From: Sarah Burrow <Sarah.Burrow@arun.gov.uk>
Sent: 22 February 2022 13:35
To: Planning.Responses <Planning.Responses@arun.gov.uk>
Cc: Anita Gardner <Anita.Gardner@arun.gov.uk>
Subject: RE: Planning Consultation on: WA/5/22/PL

Engineers Comments Regarding Surface Water Drainage

Application No: WA/5/22/PL

Site Address: Morelands Arundel Road Fontwell BN18 0SB

Trial Pit No:	TP1	Test No:	1	Date:	05/11/2021
Length (m):	1.200	Datum Height:			0.00 m agl
Width (m):	0.40	Granular infill:	None		
Depth (m):	1.50	Porosity of infill:	1	(assumed)

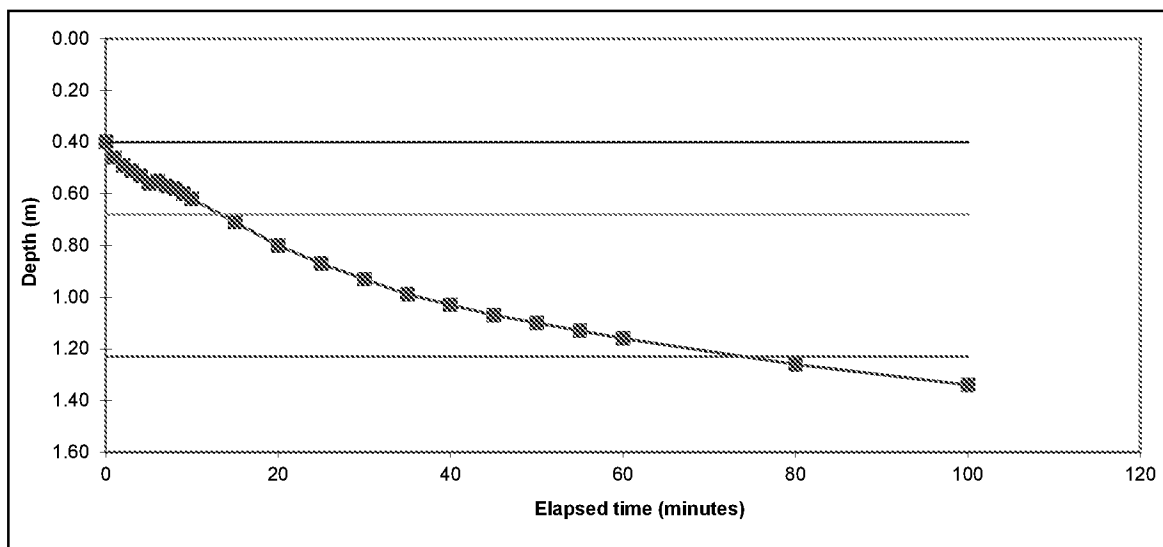
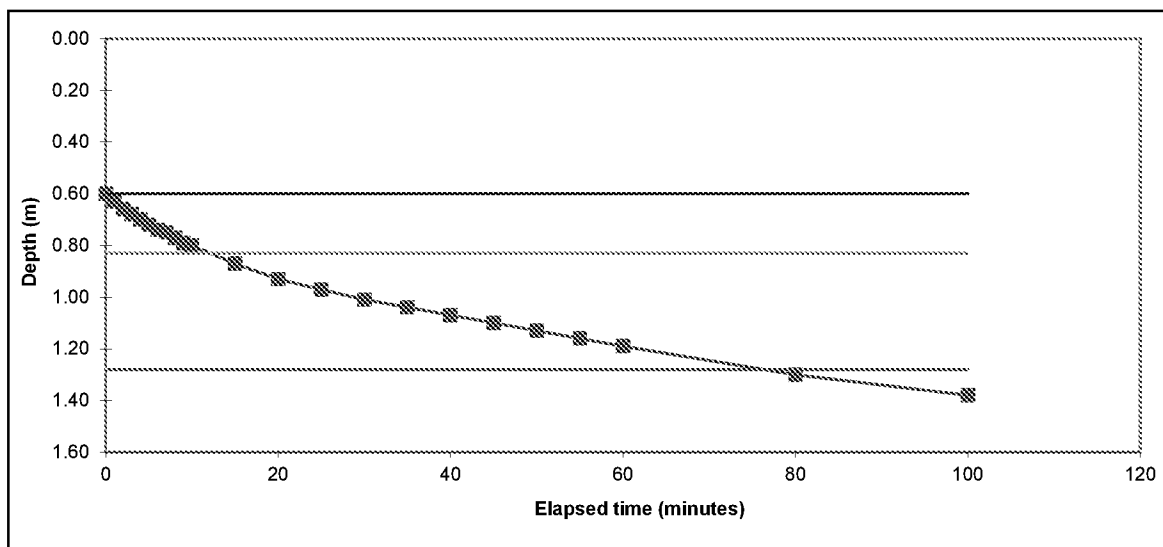
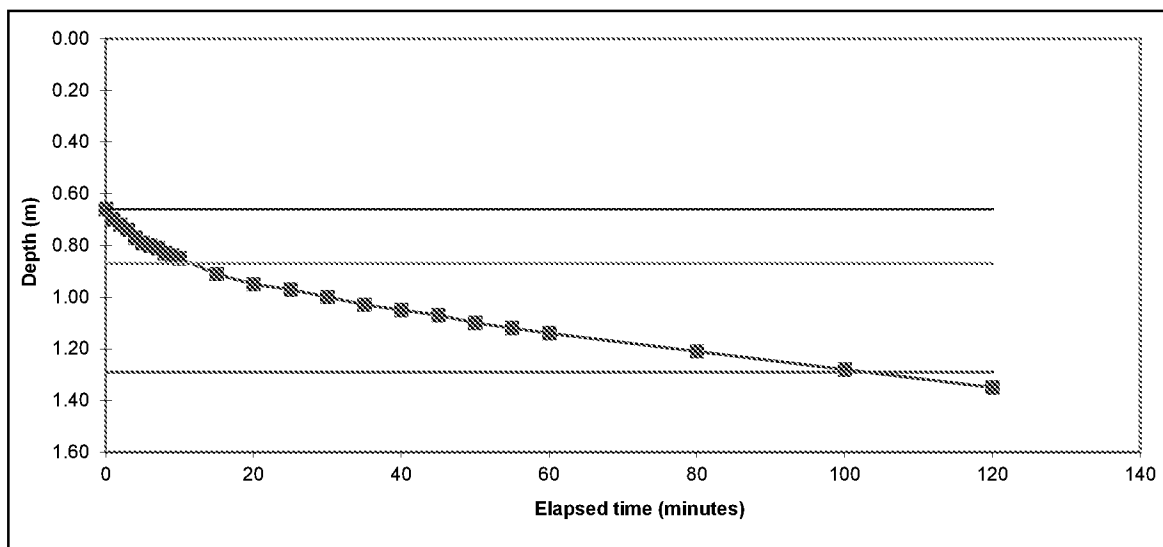
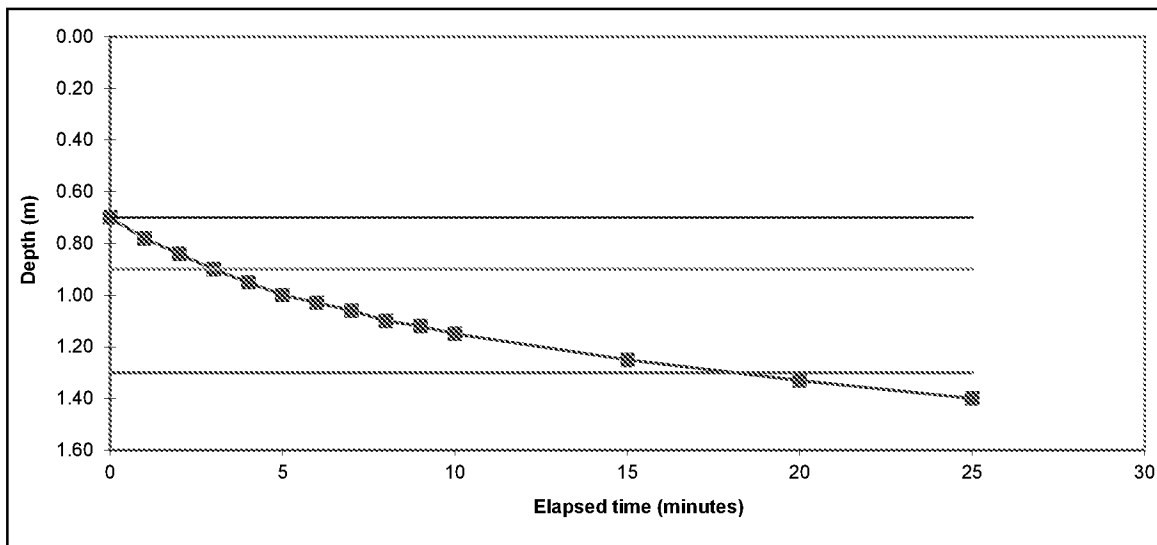
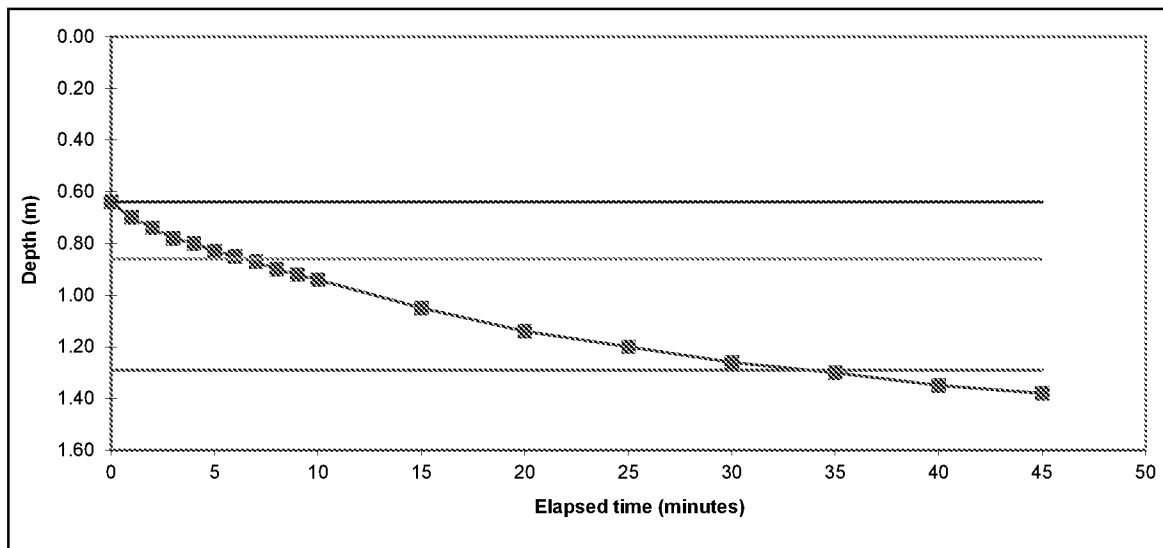
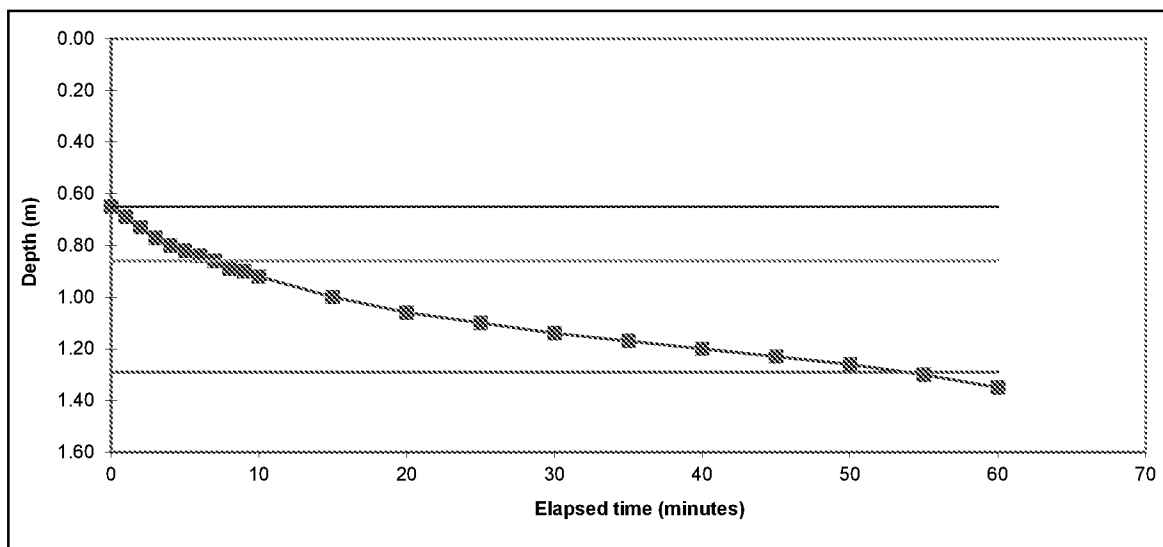
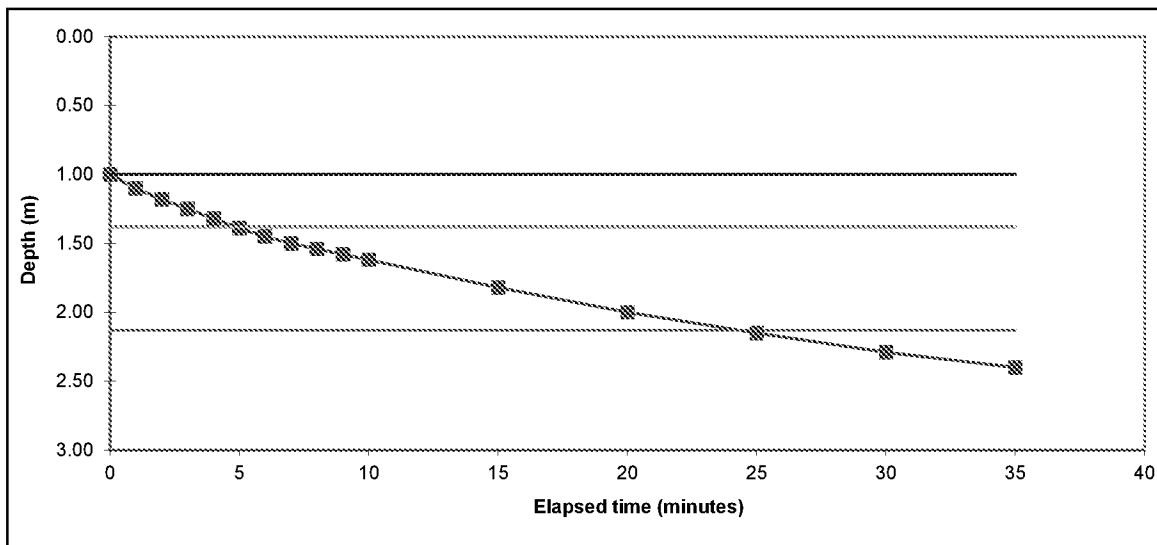
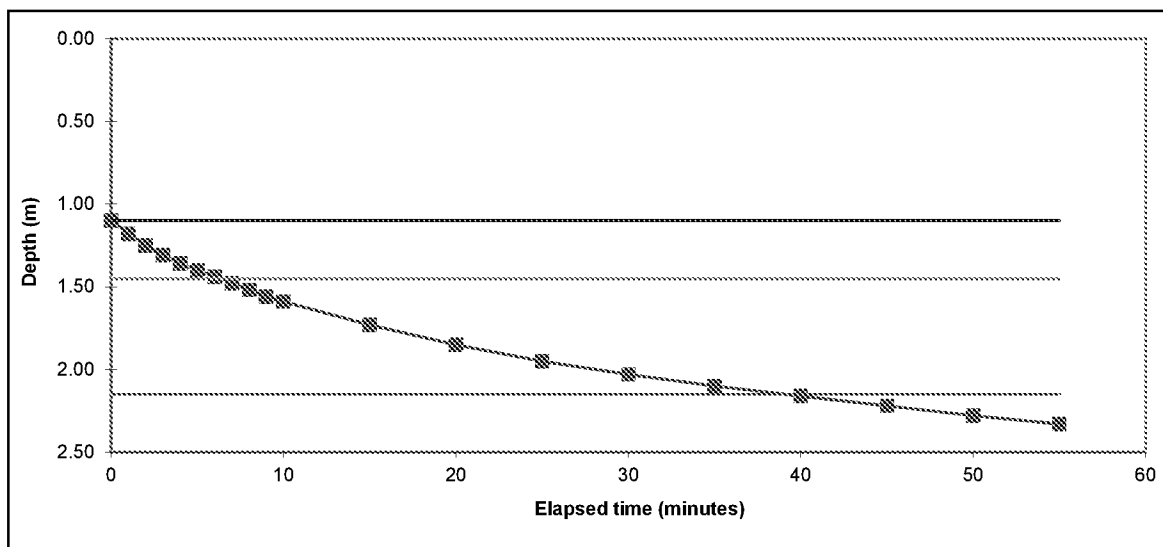
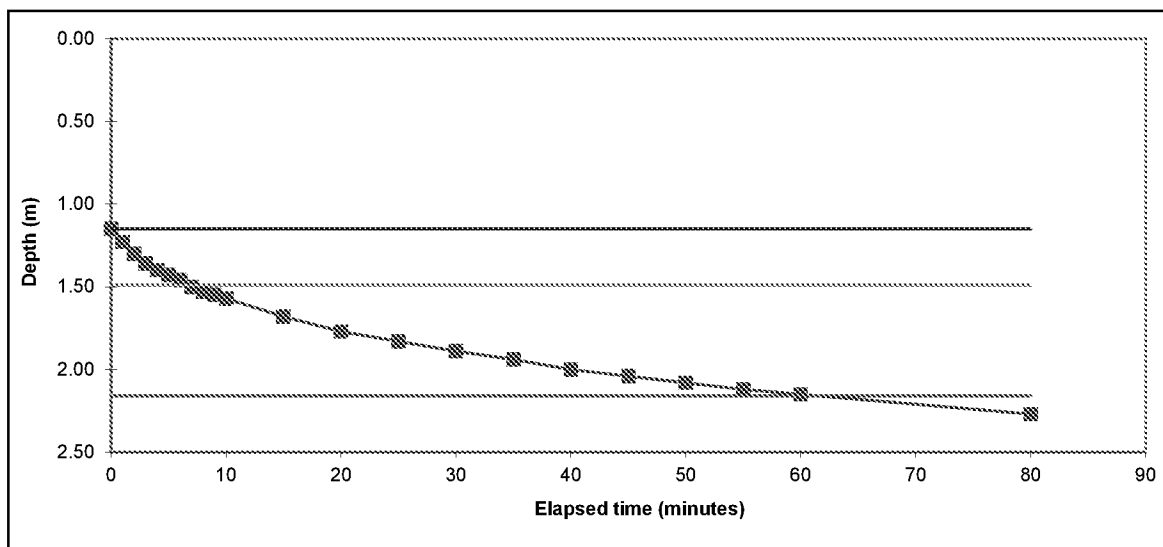
The application is within the Lidsey Treatment Catchment, therefore surface water drainage design should be carefully considered. The applicant has supplied an FRA and surface water drainage strategy. They have undertaken favourable infiltration testing in November and propose to dispose of surface water via soakaway and permeable paving.

Whilst we are agreeable to the strategy, I am not satisfied with the site investigations to support the design. All infiltration testing should be completed in the winter months (ideally January or February) when the ground is saturated and I can see no evidence of winter groundwater monitoring. For a development of this scale we would expect to see groundwater monitored from December to March at one location. The infiltration tests must then be based above the highest recorded (or anticipated) groundwater level, these tests should correspond with the depth of the proposed infiltration structures. No testing has been done at a shallow depth to support the design of permeable paving.

Once further site investigations have been undertaken the drainage design will need to be updated and detailed. The level of detail required for a drainage layout and supporting construction detail drawings are all available online following the link in the informative suggested below. It is strongly advised that the applicant (or their consultant) familiarises themselves with our drainage checklist and submits a completed copy of this with any application to discharge conditions.

"Infiltration rates for soakage structures are to be based on percolation tests undertaken in the winter period and at the location and depth of the proposed structures. The percolation tests must be carried out in accordance with BRE365, CIRIA R156 or a similar approved method and cater for the 1 in 10 year storm event plus 40% on stored volumes (allowance for climate change) between the invert of the entry pipe to the soakaway, and the base of the structure. It must also have provision to ensure that there is capacity in the system to contain below ground level the 1 in 100 year storm event plus 40% on stored volumes. Adequate freeboard must be provided between the base of the soakaway structure and the highest recorded annual groundwater level identified in that location. Any SuDS or soakaway design must include adequate groundwater monitoring data to determine the highest winter groundwater table in support of the design. The applicant is advised to discuss the extent of groundwater monitoring with the Council's Engineers.
